WEST SUSSEX COUNTY COUNCIL CONSULTATION

TO:	Arun District Council FAO: Maria Tomalova
FROM:	WSCC - Highways Authority
DATE:	30 August 2019
LOCATION:	7 Clock Walk, High Street, Bognor Regis, PO21 1SG
SUBJECT:	BR/199/19/PL Conversion of existing Health Centre (D1 non-residential insitution) unit to 4 No. studio flats. This application may affect the setting of a listed building.
DATE OF SITE VISIT:	n/a
RECOMMENDATION:	More Information
S106 CONTRIBUTION TOTAL:	n/a

Proposed Ground Floor Plan
YO361 - 120
1:100 @ A3
May 2019
C

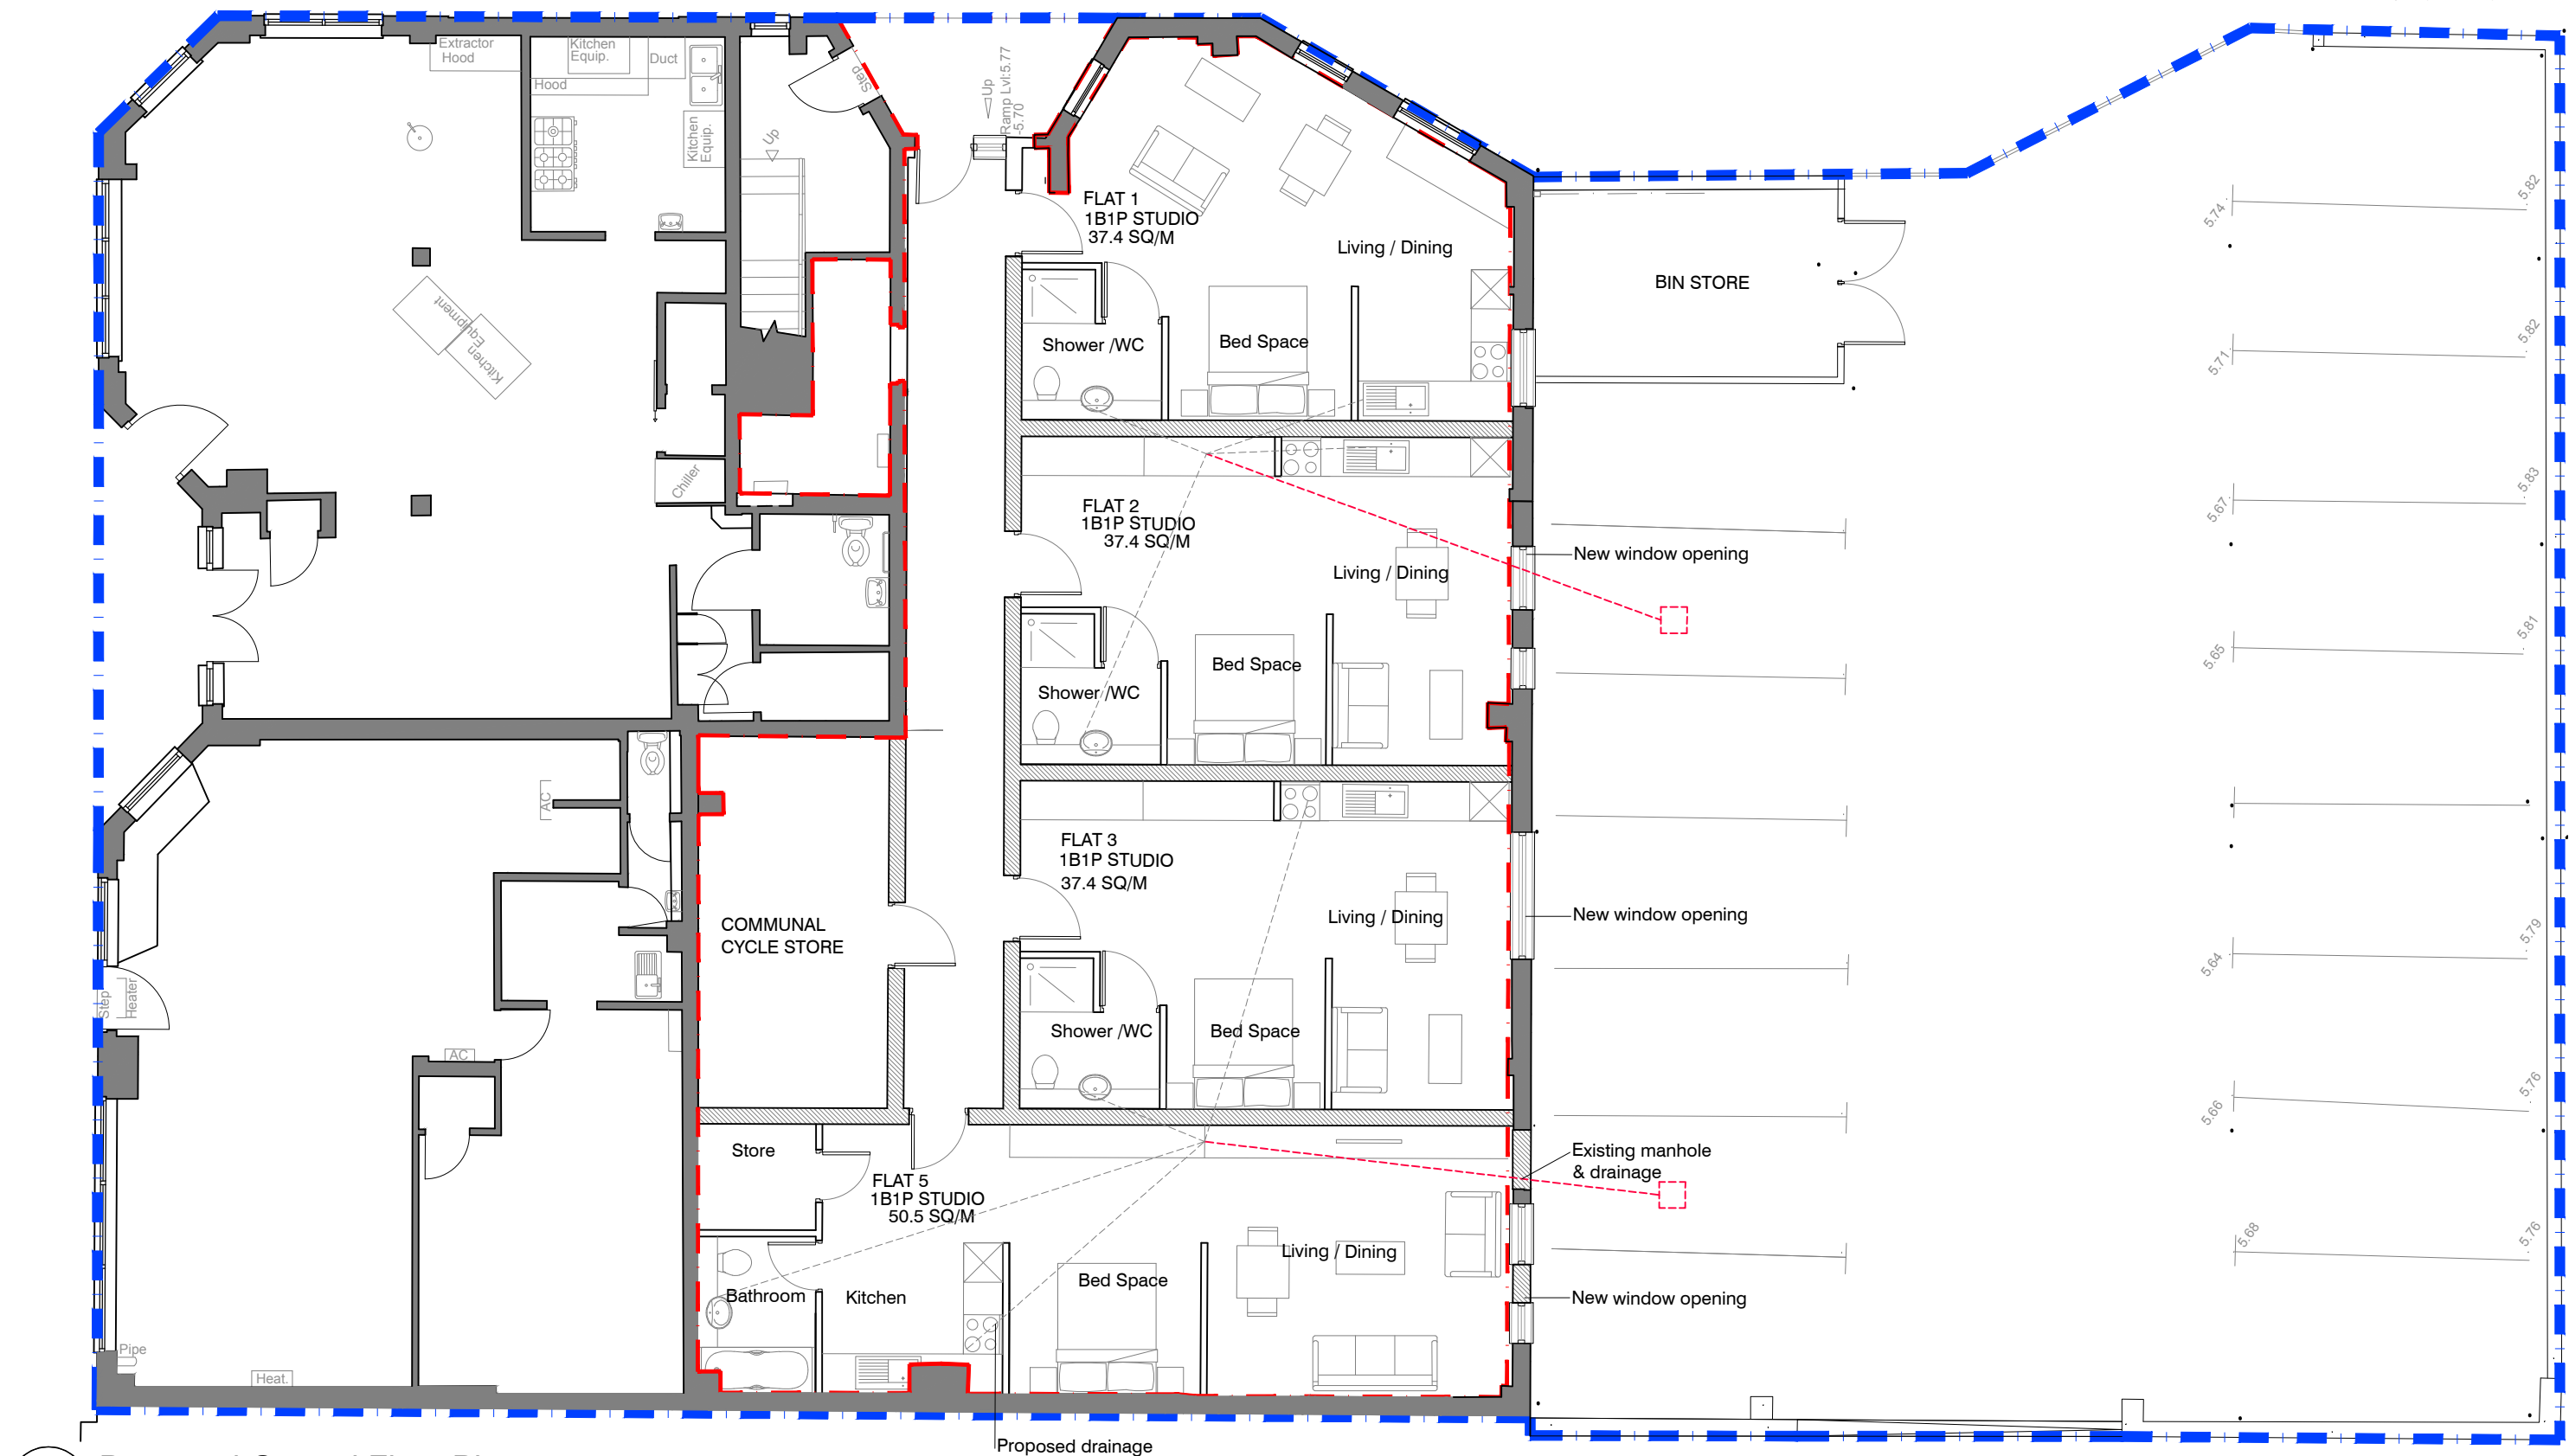
There appears to be no application form within the submitted documents. As such, the LHA is unsure whether this application proposes any parking provision for the proposed flats. The proposed site plan indicates that there is a car park to the rear of the site, but it is unclear whether this is proposed to provide any parking for the development. The applicant is requested to clarify whether there is any proposed parking provision and if so, demonstrate parking layout on a plan.
